ENGINEERING PLANNING REPORT

A PROPOSED STRATEGIC HOUSING DEVELOPMENT

BALLYMANY ROAD, NEWBRIDGE, CO. KILDARE

3.9 Response to the Roads, Transportation & Public Safety Department Comments Contained in the Kildare County Council Section 6(4)(b) Report

Drawing file: Engineering / D1920-MAL-00-XX-C-002 Road Layout Sheet 1 of 4.pdf

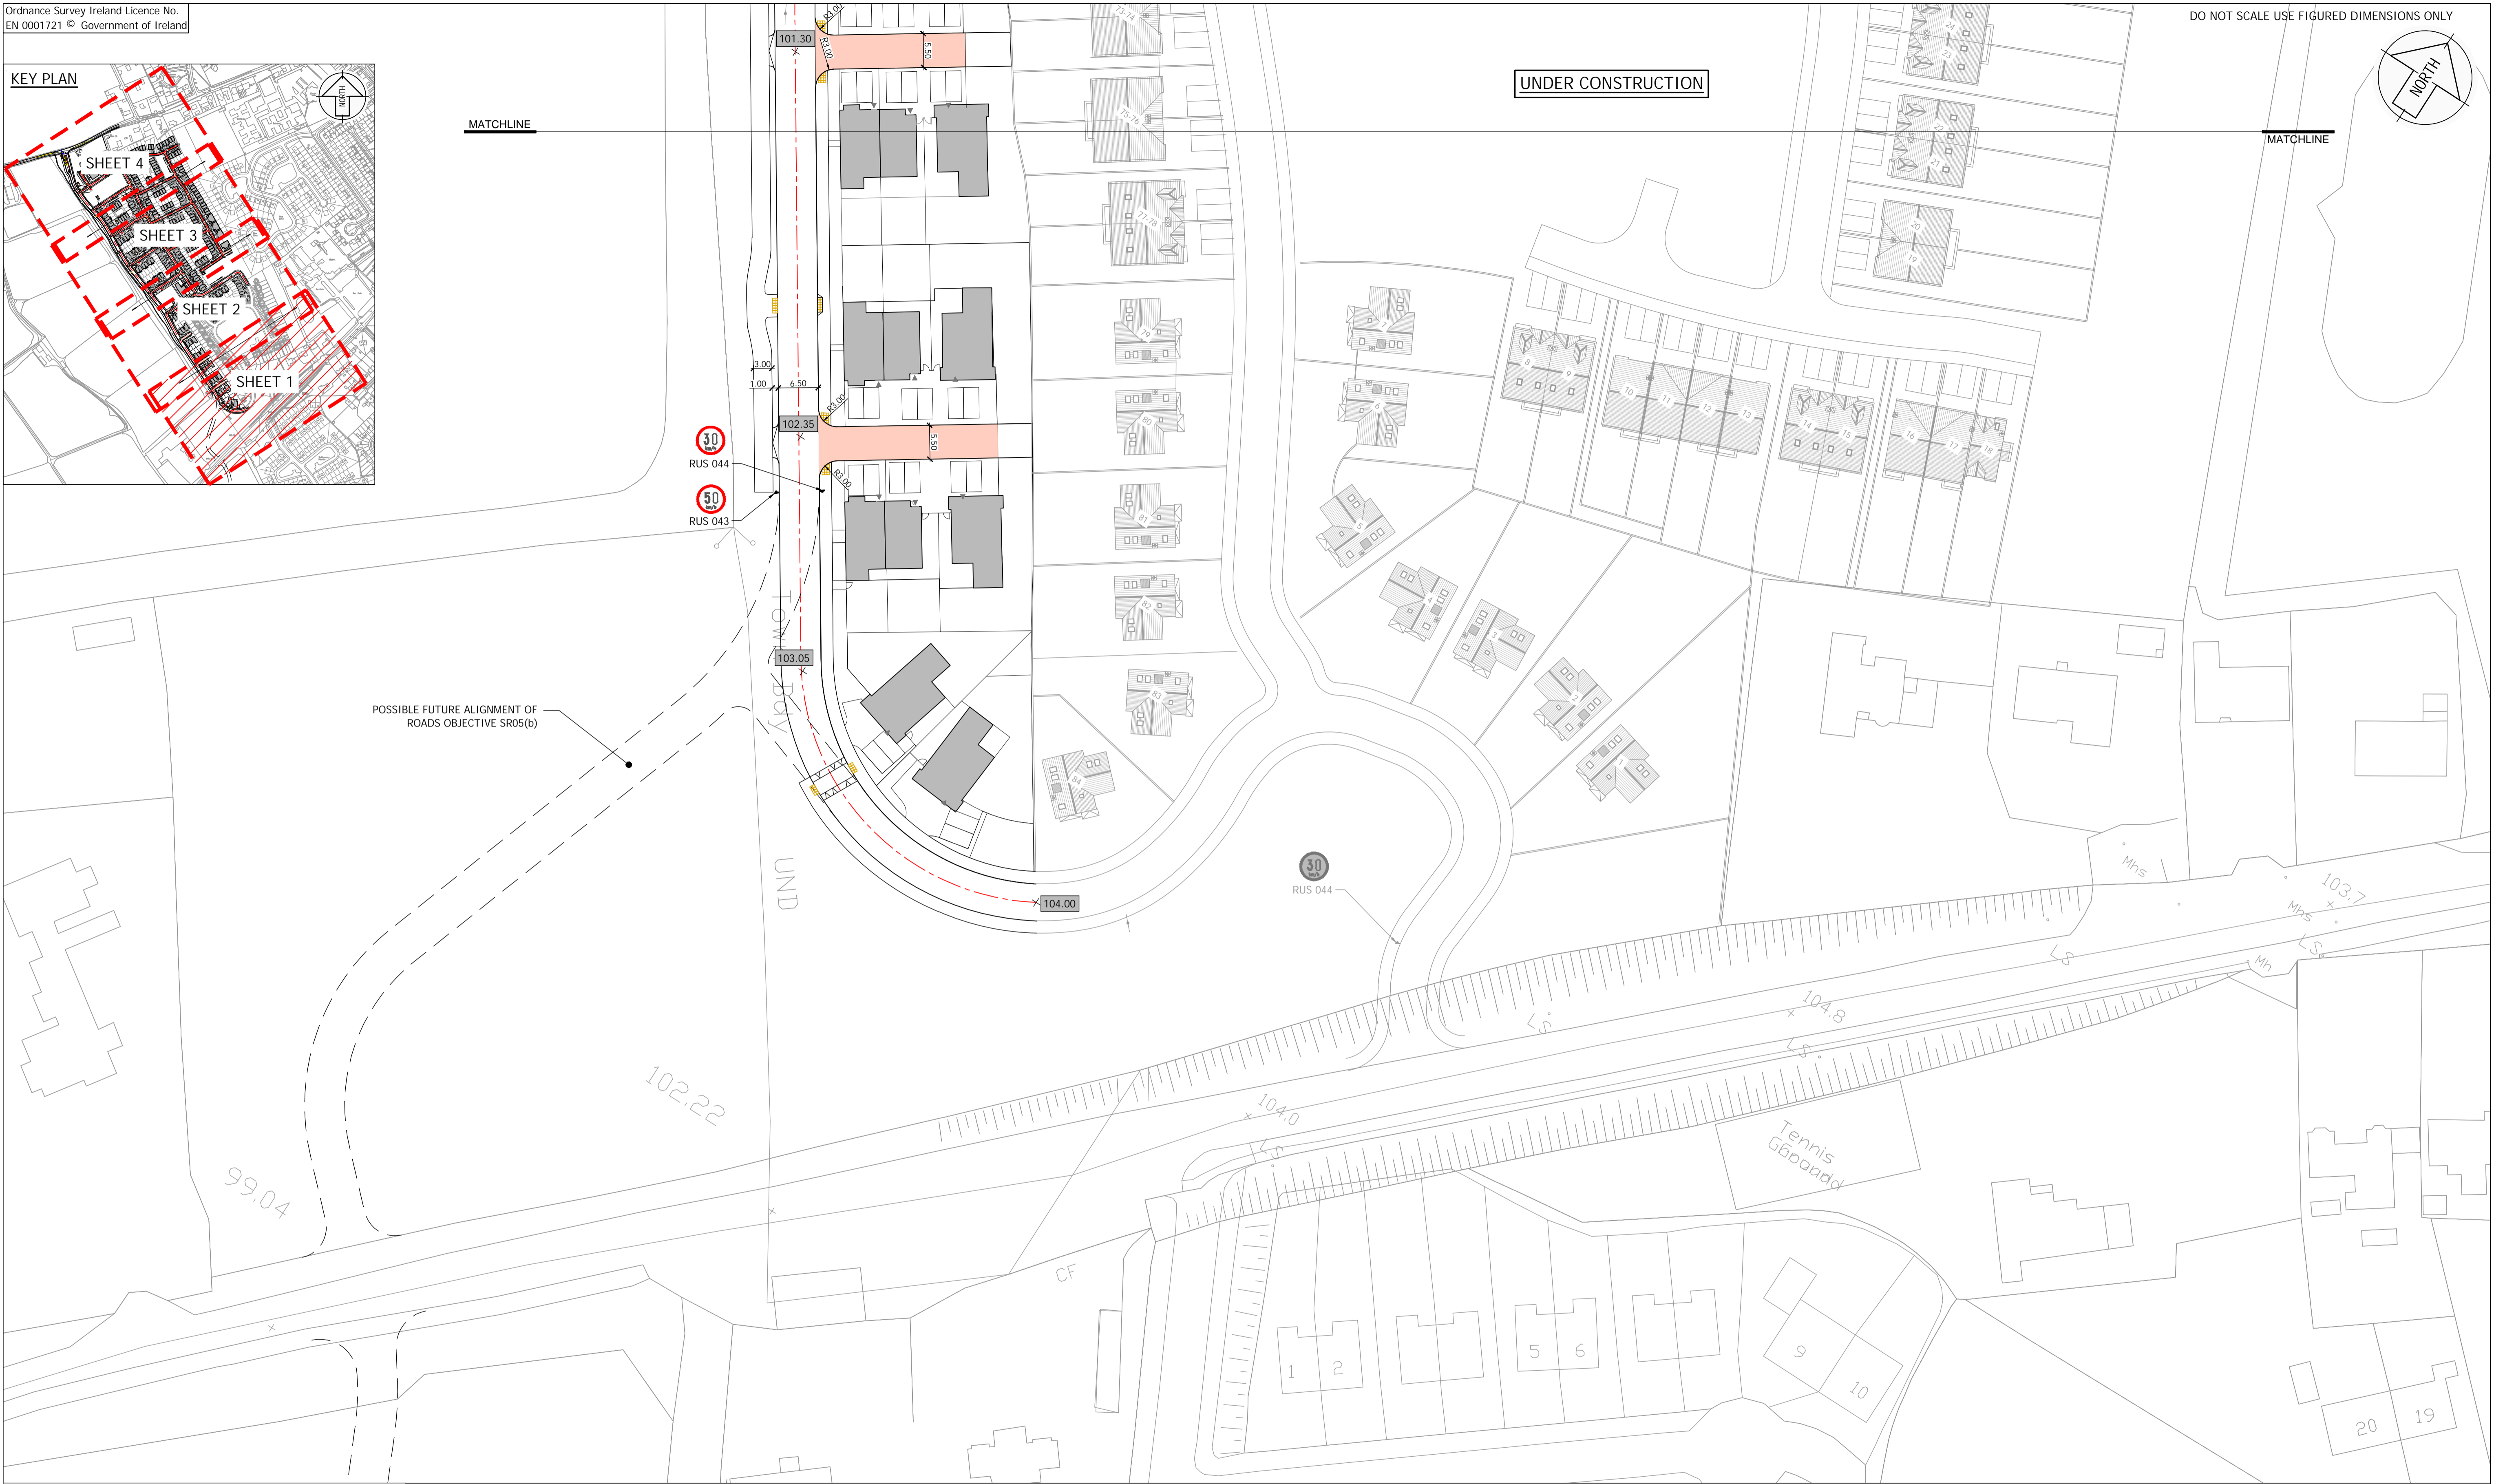
Junction Corner Radii: Junction radii have been generally set at 3.0m and this is indicated on MAL drawing No's D1920-MAL-00-XX-C-002, D1920-MAL-00-XX-C-003, D1920-MAL-00-XX-C-004 and D1920-MAL-00-XX-C-005.

TACTILE PAVING DETAILS AT UNCONTROLLED PEDESTRIAN CROSSINGS
SCALE: NTS

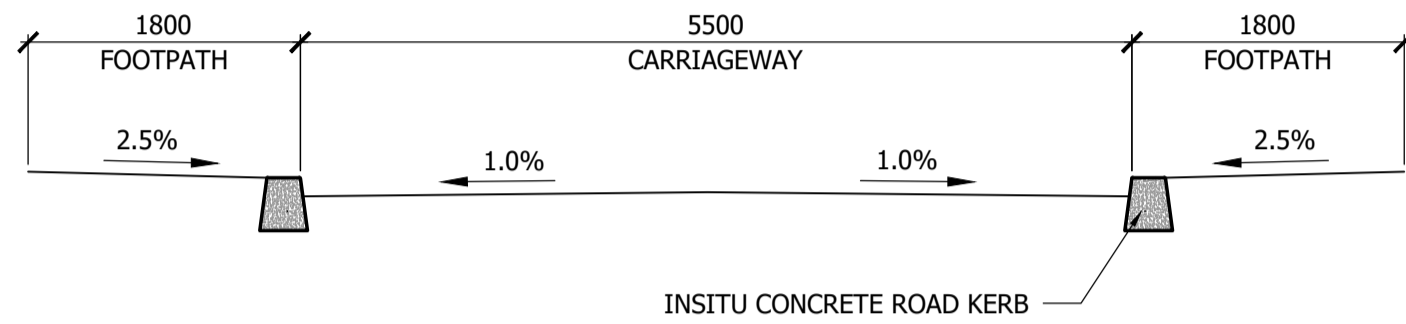
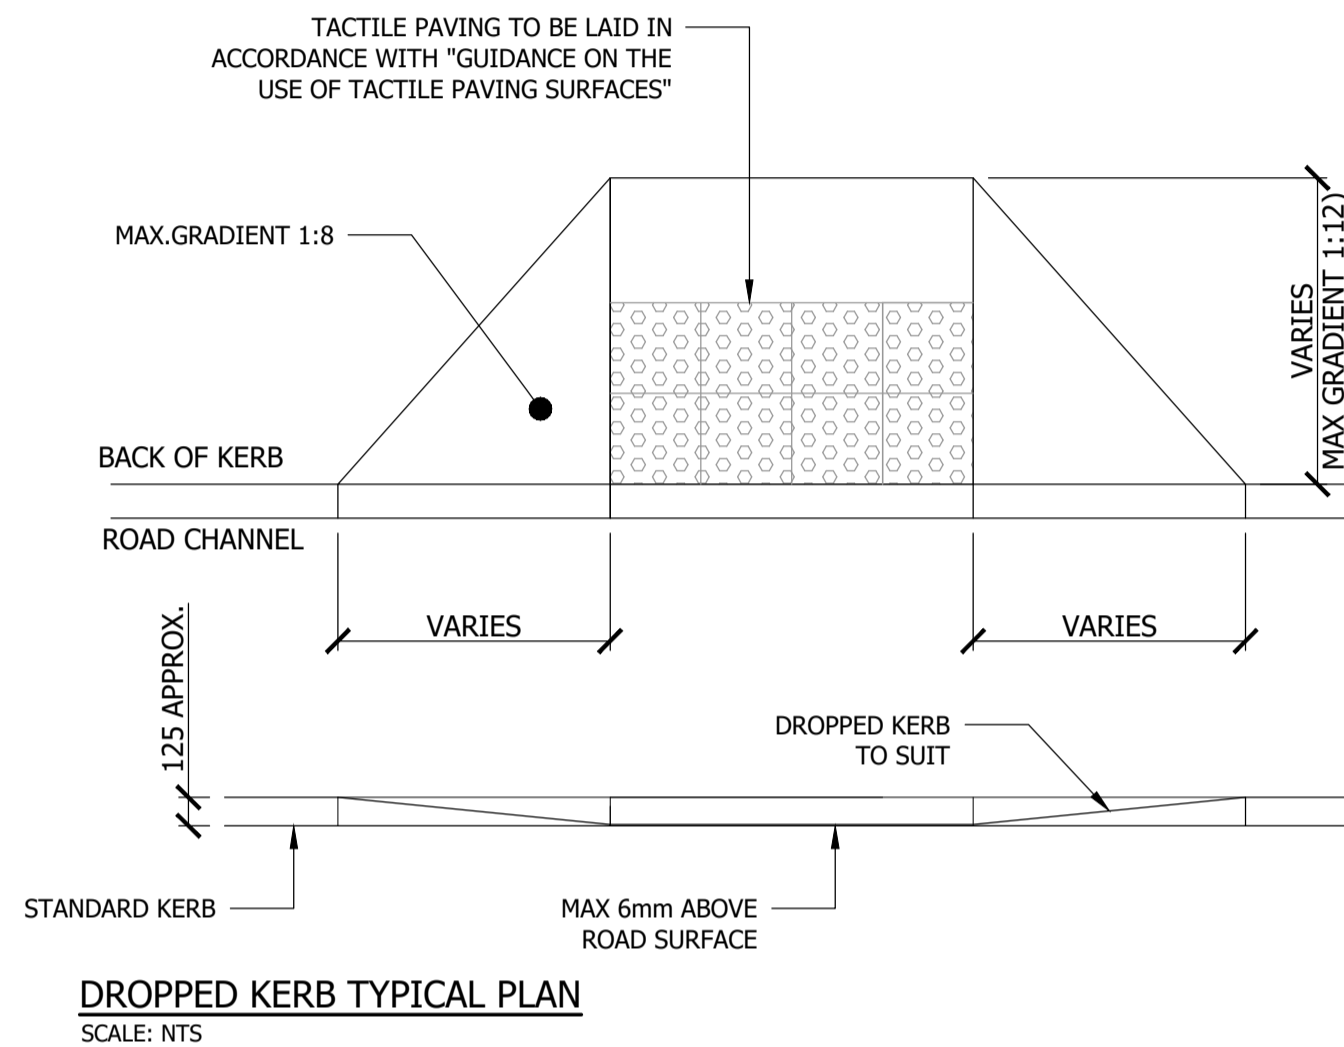
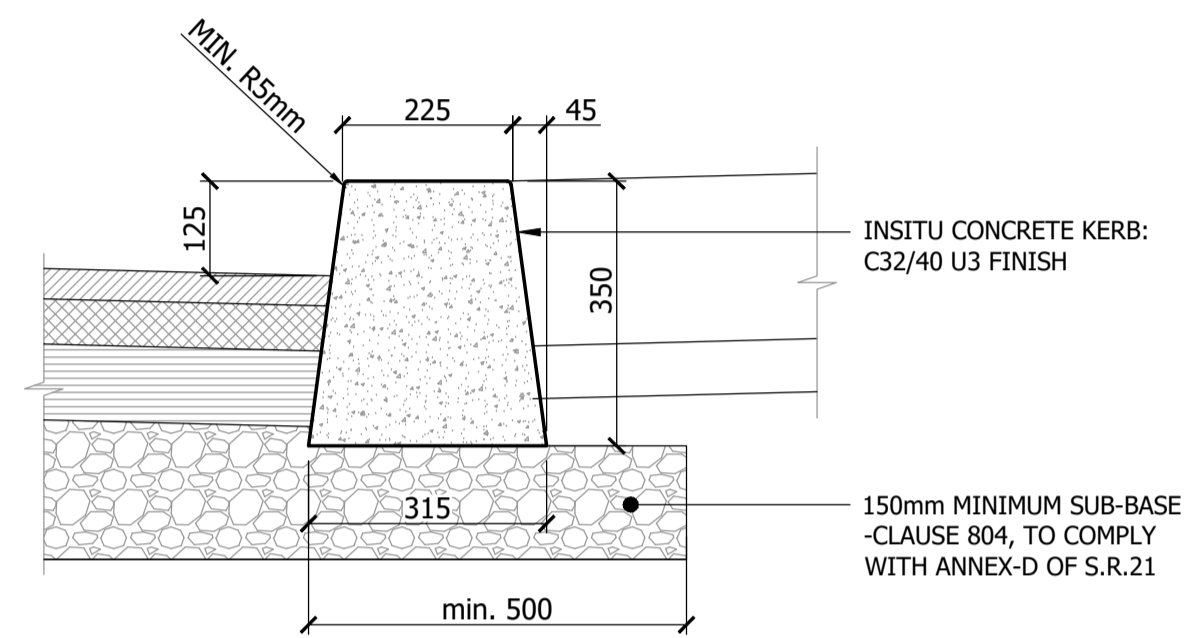
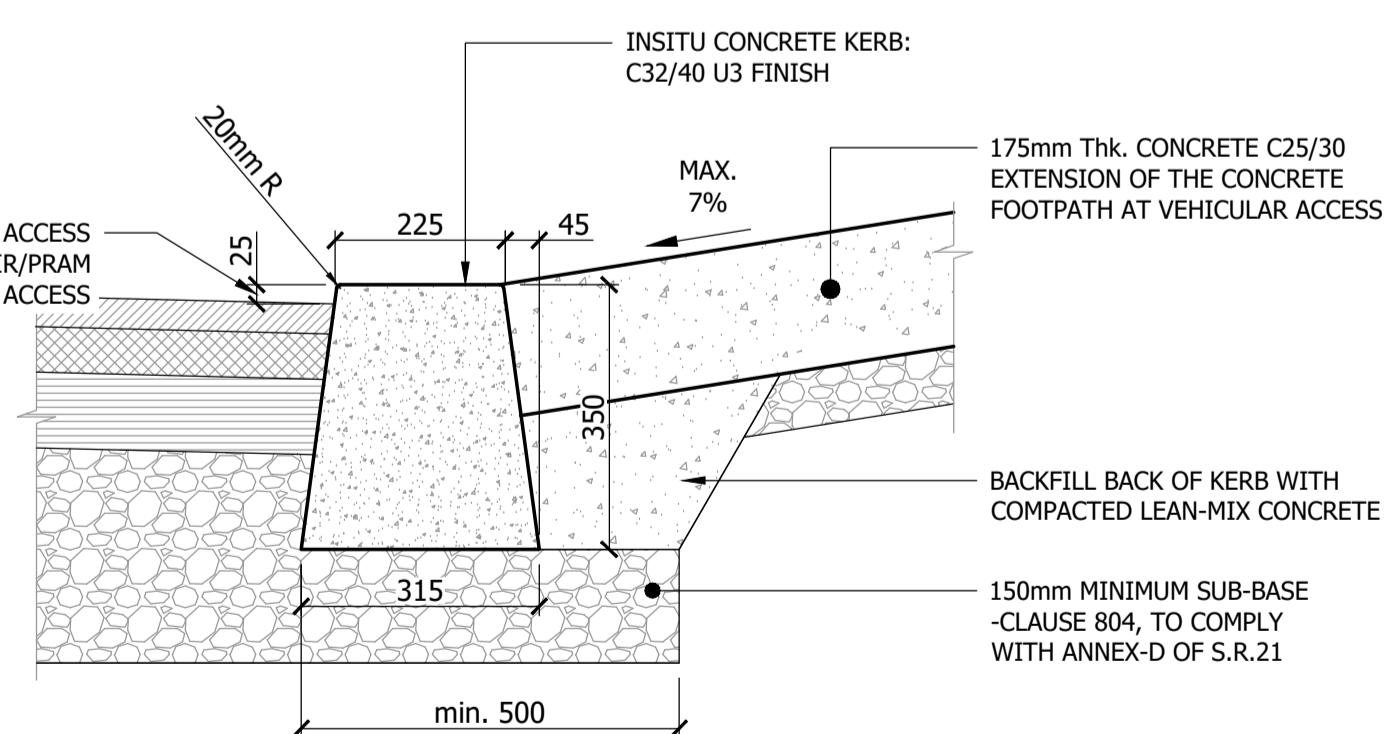
Detailing of Pedestrian Crossings: MAL drawing No D1920-MAL-00-XX-C-035 includes details of the uncontrolled pedestrian crossings.

CARRIAGEWAY BUILD UP
SCALE 1:10

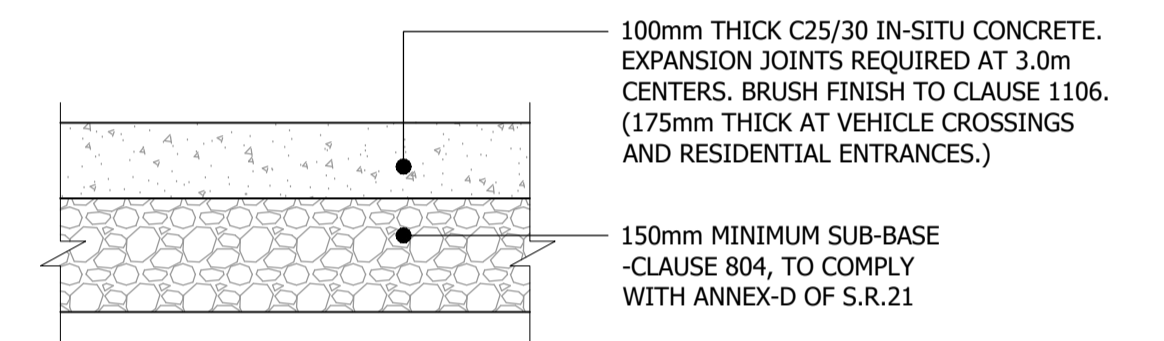
Carriageway Surface Course: MAL drawing No D1920-MAL-00-XX-C-035 includes details of the carriageway surface course which is in accordance with the stated requirements of the Roads, Transportation & Public Safety Department of Kildare County Council.
